Ribble Valley Borough Council  
Council Offices  
Church Walk,  
Clitheroe  
Lancashire  
BB7 2RA

Phone: 0300 123 6780  
Email: [Kathryn.Walsh@lancashire.gov.uk](mailto:Kathryn.Walsh@lancashire.gov.uk)  
Your ref: 3/2024/0969  
Our ref: 3/2024/0969/HDC/KW  
Date: 29 January 2025

**Location:** 24 Durham Road Wilpshire BB1 9LR  
**Proposal:** Proposed change of use from garage/workshop to commercial art studio and pottery for producing, stocking, selling online and teaching small groups (up to 6 at a time) three times per week.  
**Grid Ref:** 369008 433108

Client: Marion Walsh		
Project: Proposed Alterations 24 Dunham Road Wiltshire		
Dwg title: Proposed Site Plan		
Scale @ A4: 1:200	Date: 04.12.24	Drawn by: PD
Drawing no. 1682 - 102		Rev. C

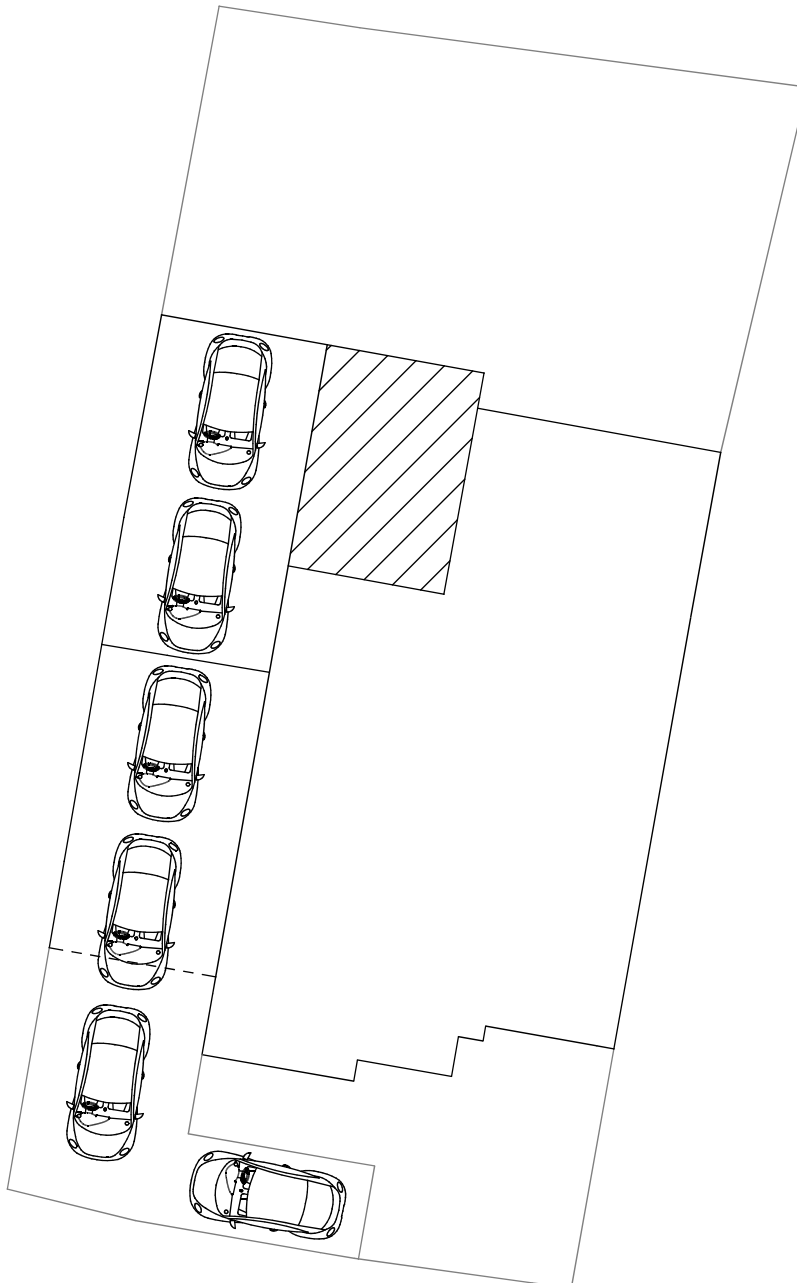
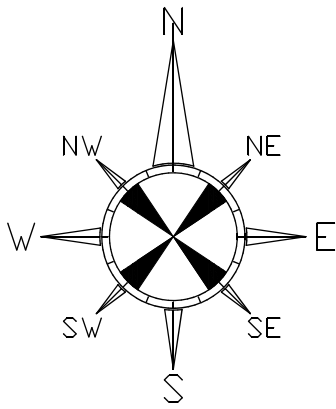
In order for the LHA to support the application, the applicant will be required to not only provides off-street parking for the existing dwelling but also provide car parking provisions for the proposed development. Having reviewed the site, the LHA expect that additional off parking provisions are provided within the site frontage. There is space for 2 additional car spaces on the East side of the site frontage, this will require the front wall to be removed and the area be hard surfaced.

As such an amended plan should be provided showing the required amendments to the driveway to allow for addition parking on site. The supporting documentation should also be amended to indicate no more than 4 attendees each session in order for the LHA to support the application.
